# **AQUIND INTERCONNECTOR**

## **Environmental Statement – Volume 3 – Appendix 20.1 Consultation Responses**

Document Ref : 6.3.20.1

**DATE: 14 NOVEMBER 2019**

Figure 20.1
Flood Risk Constraints
Sheet 1 of 7

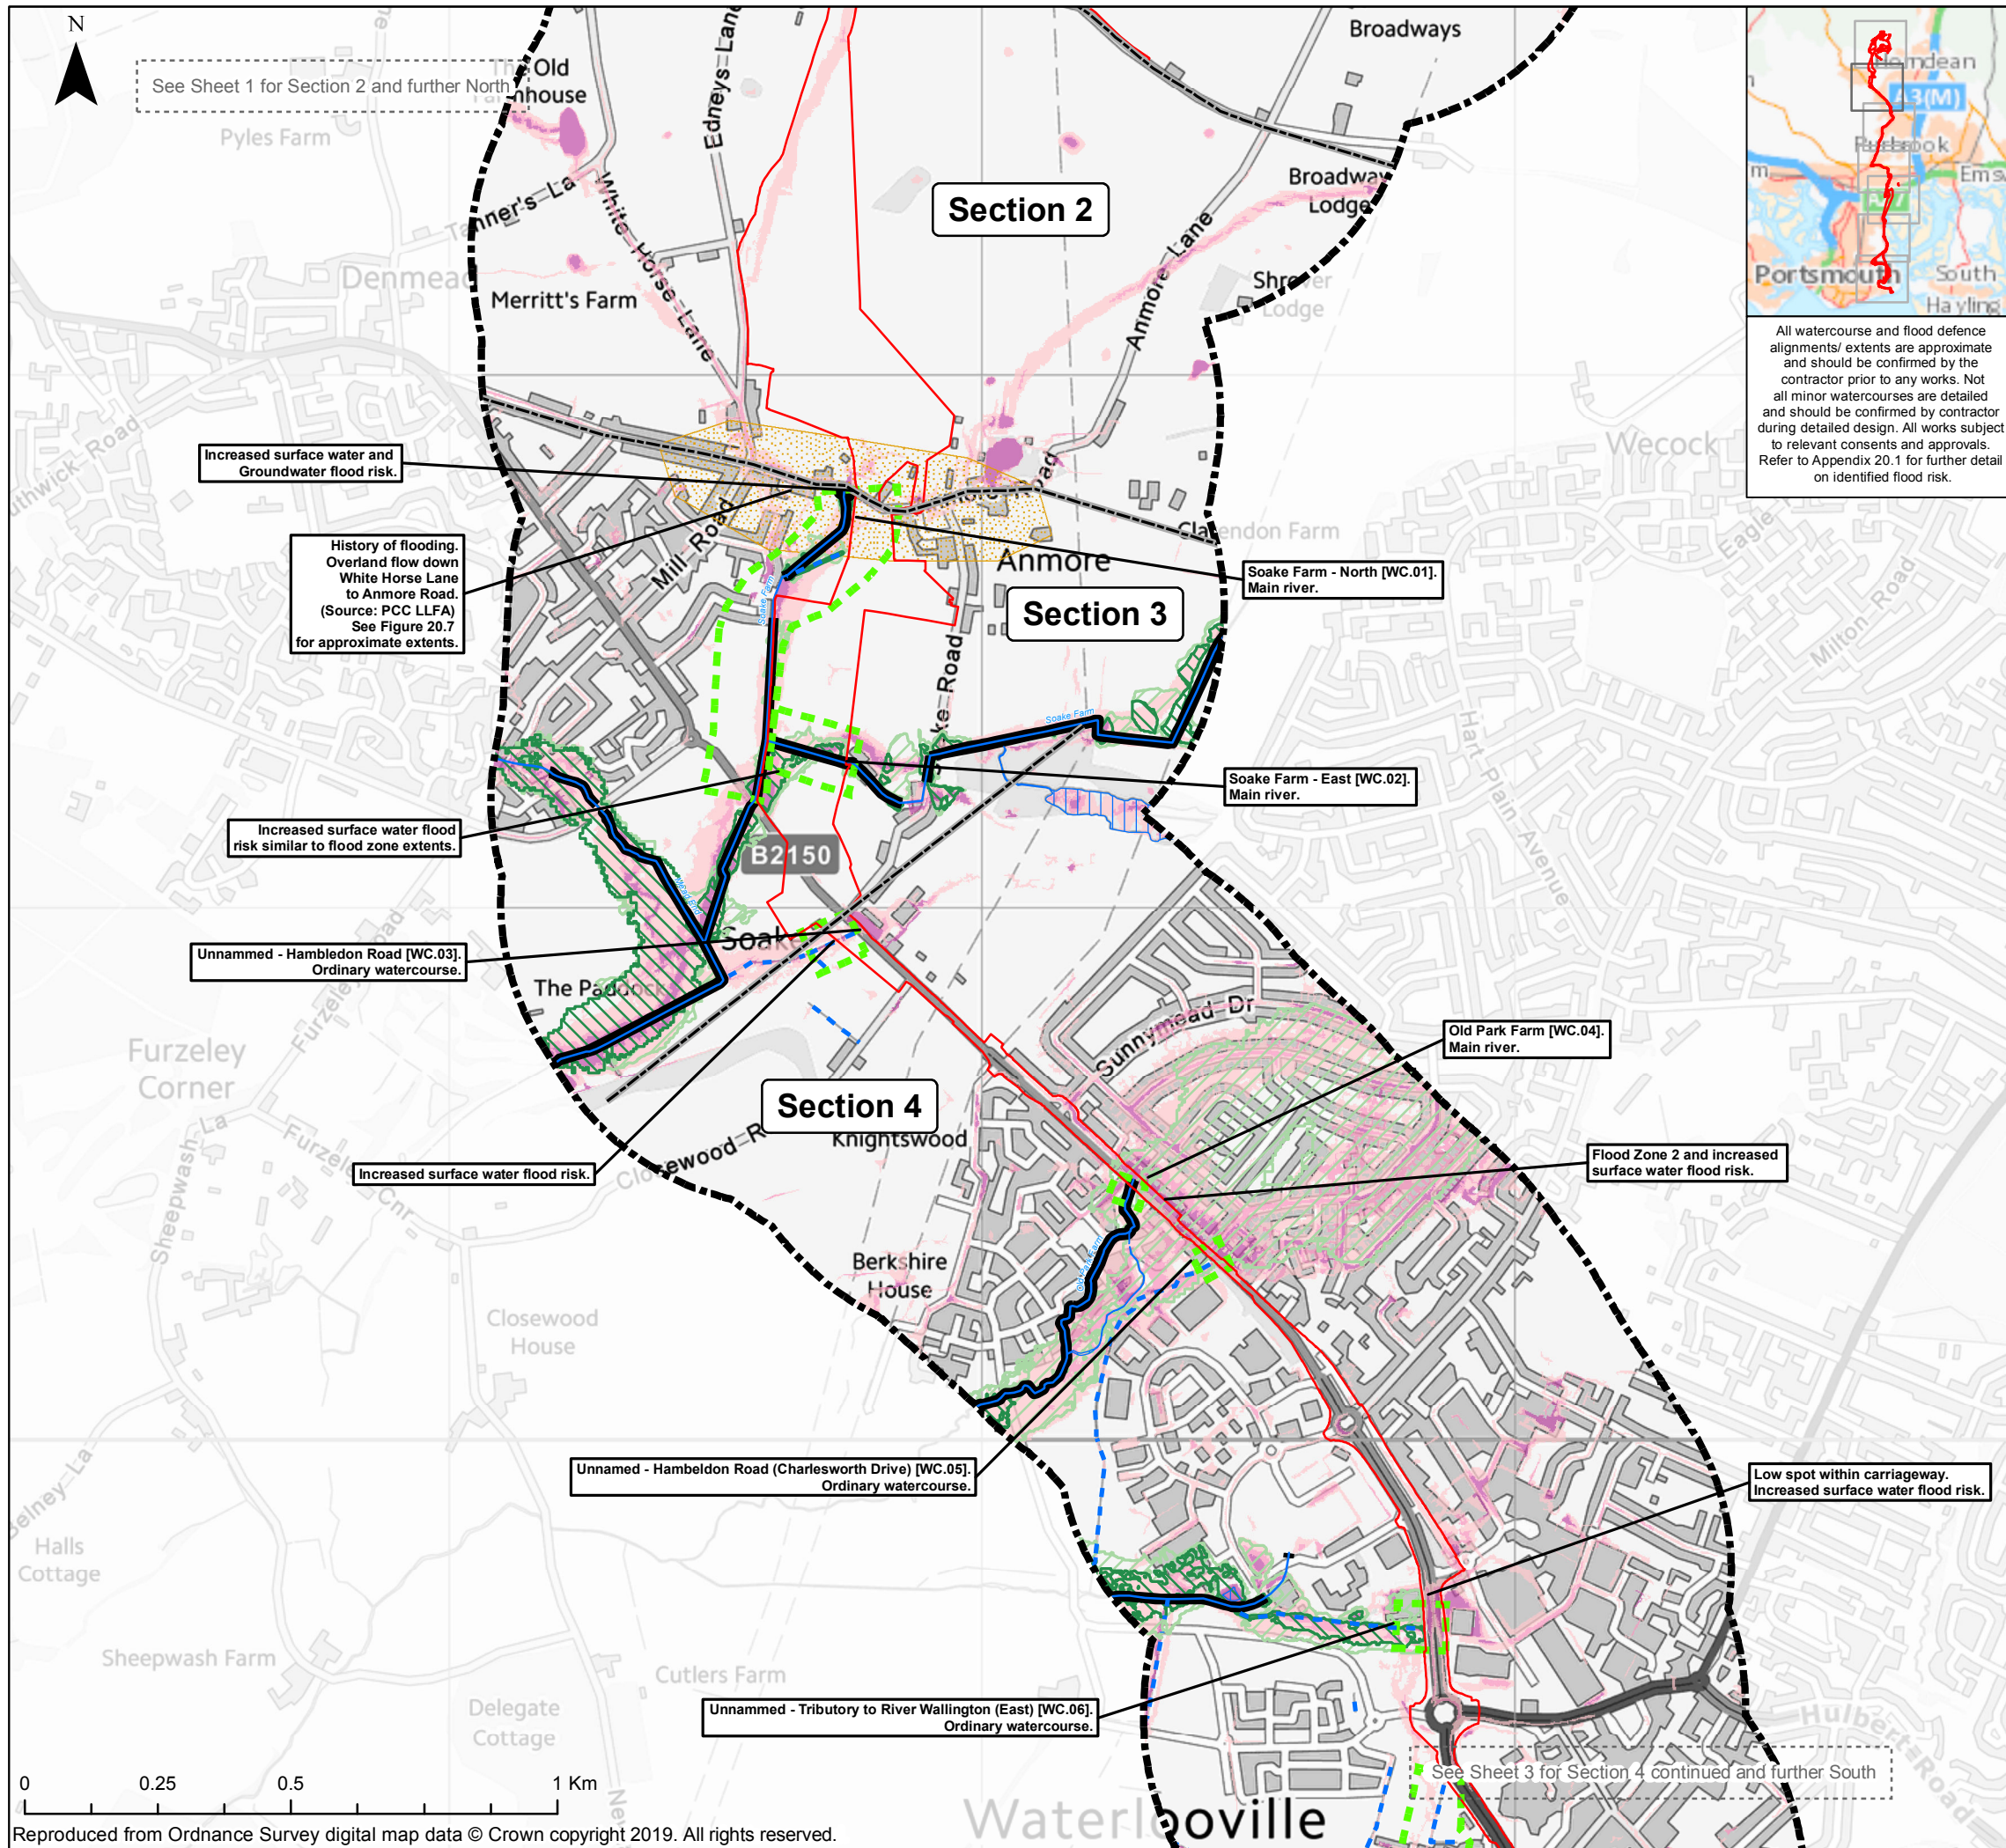
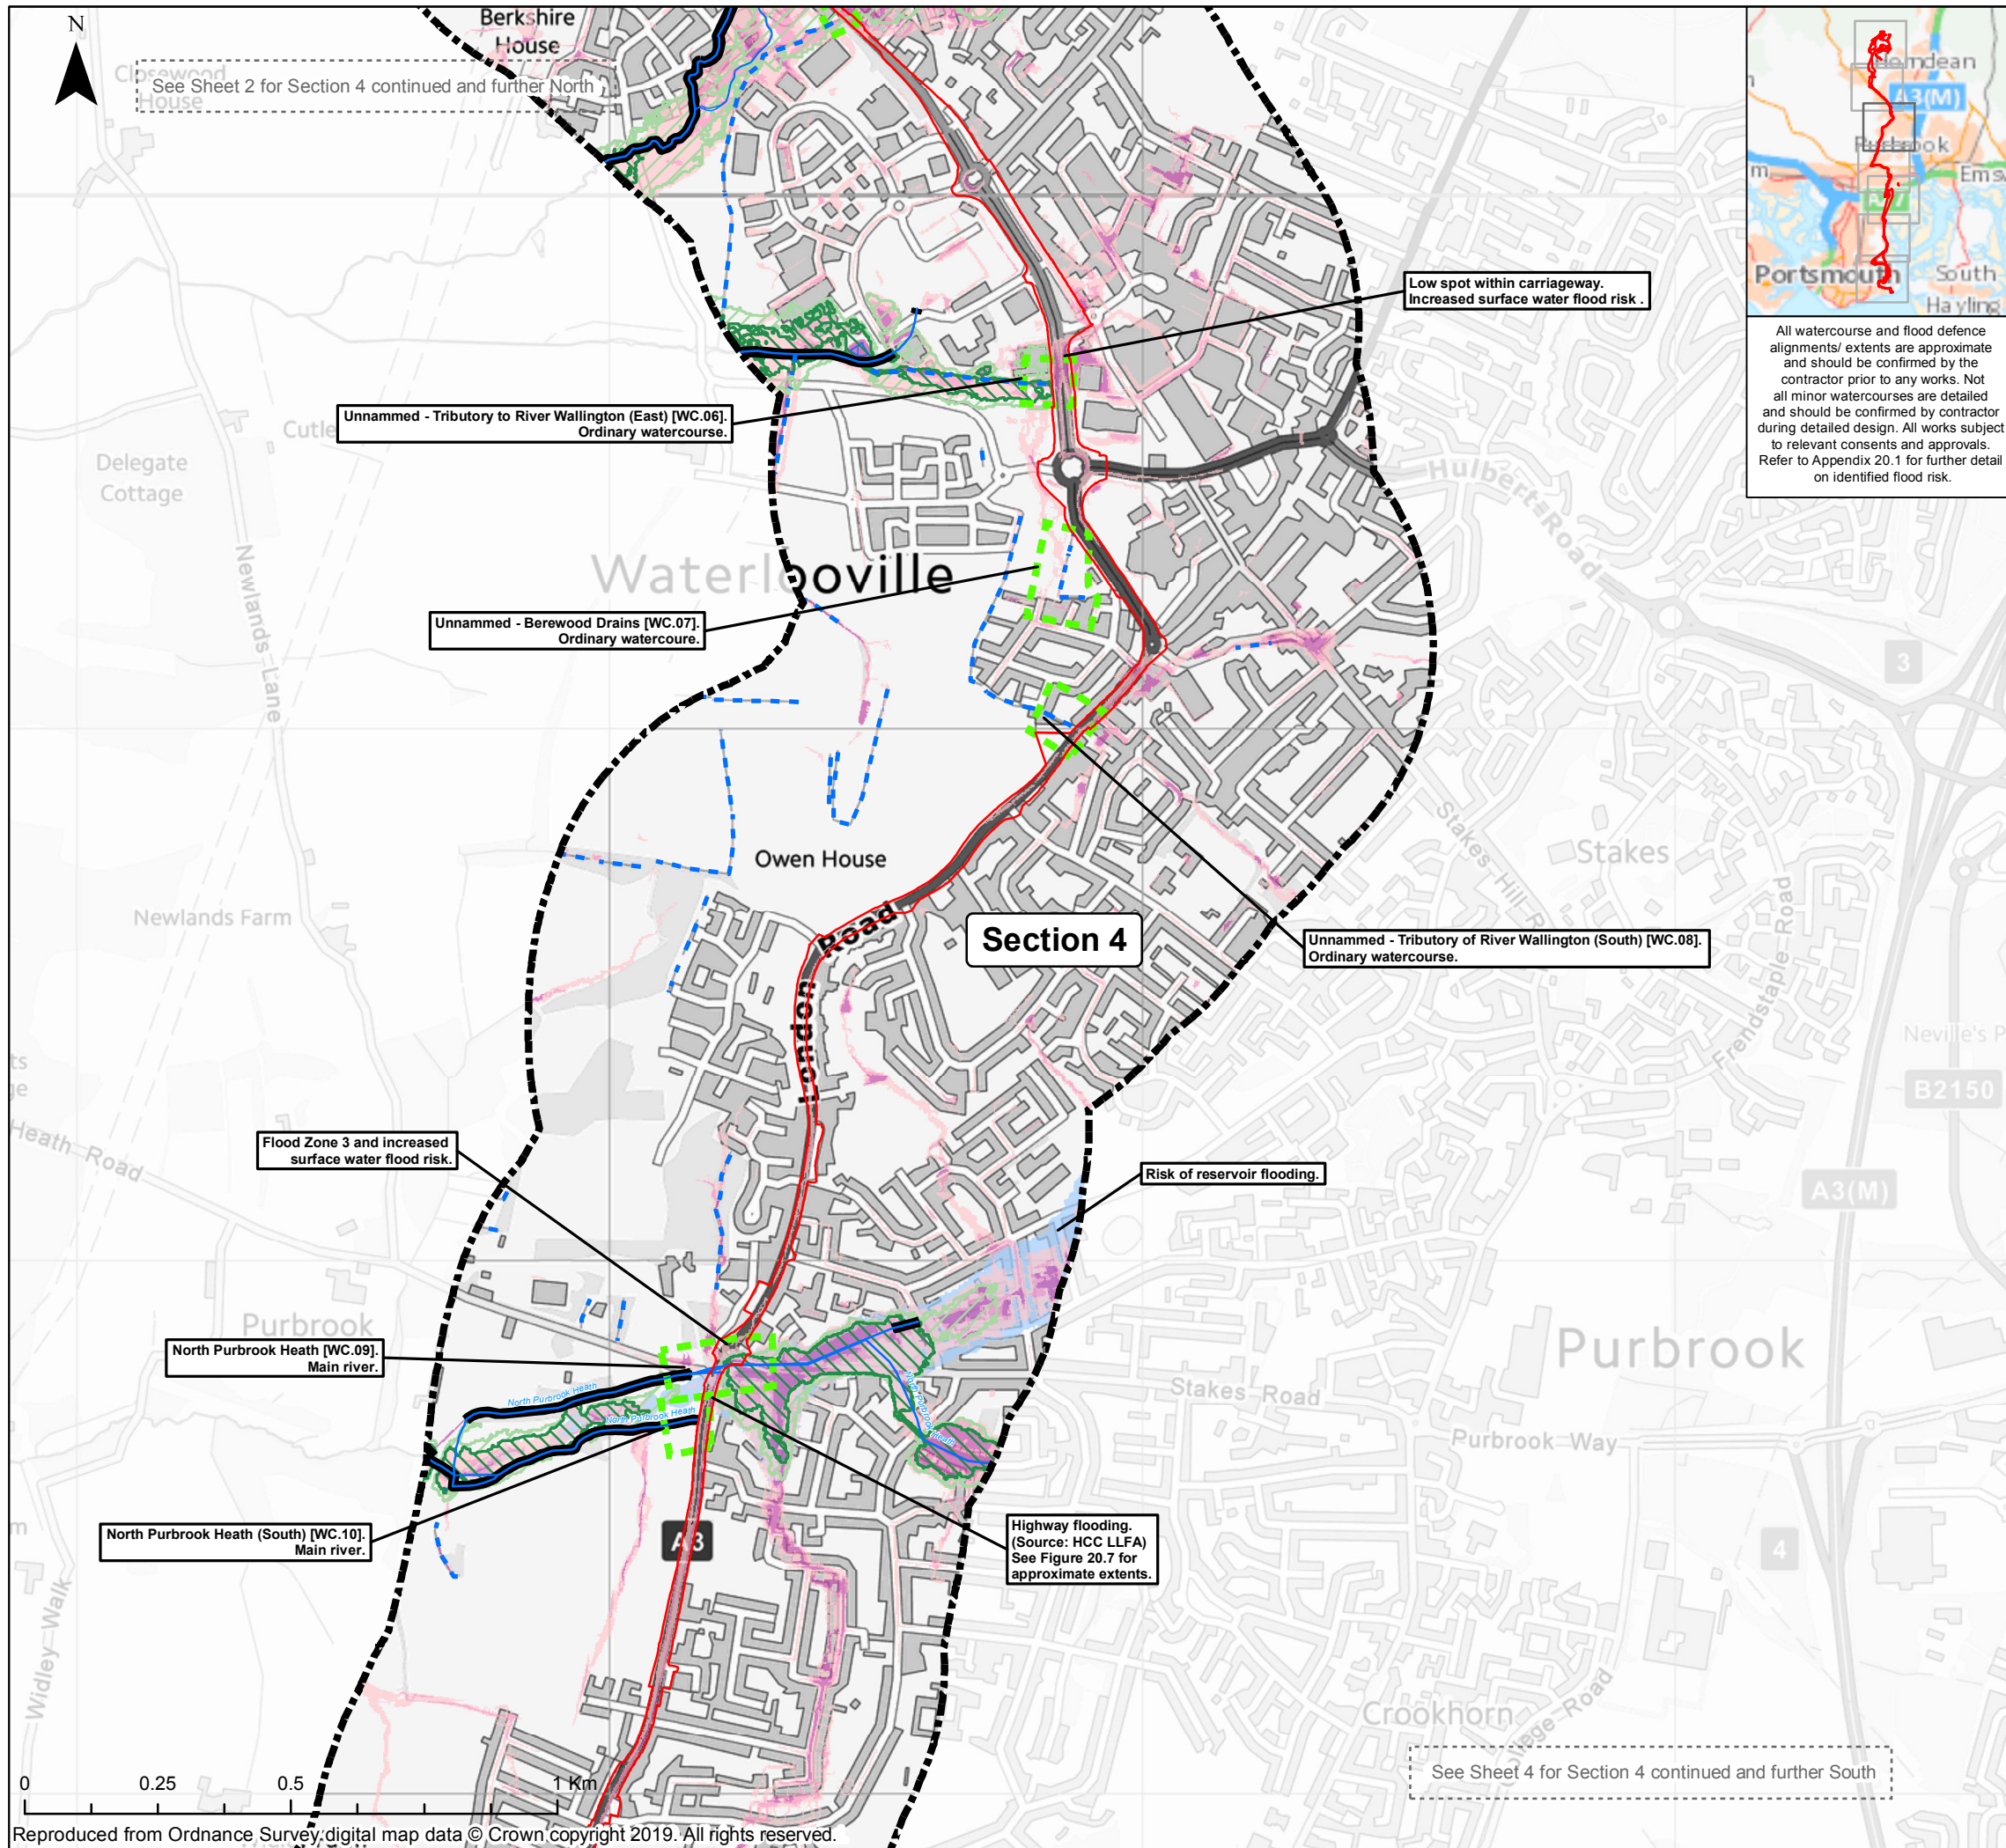
4.17.8	The Scoping Report does not include figures to show the location of potential receptors or the flood maps for the area. The ES must include clear and appropriate figures to support the impact assessment, including those in support of any FRA and WFD Assessment.	Figures 20.1 to 20.8 of the ES Volume 2 (document reference 6.2.20.1 to 6.2.20.8) support the assessment, FRA and WFD assessment.
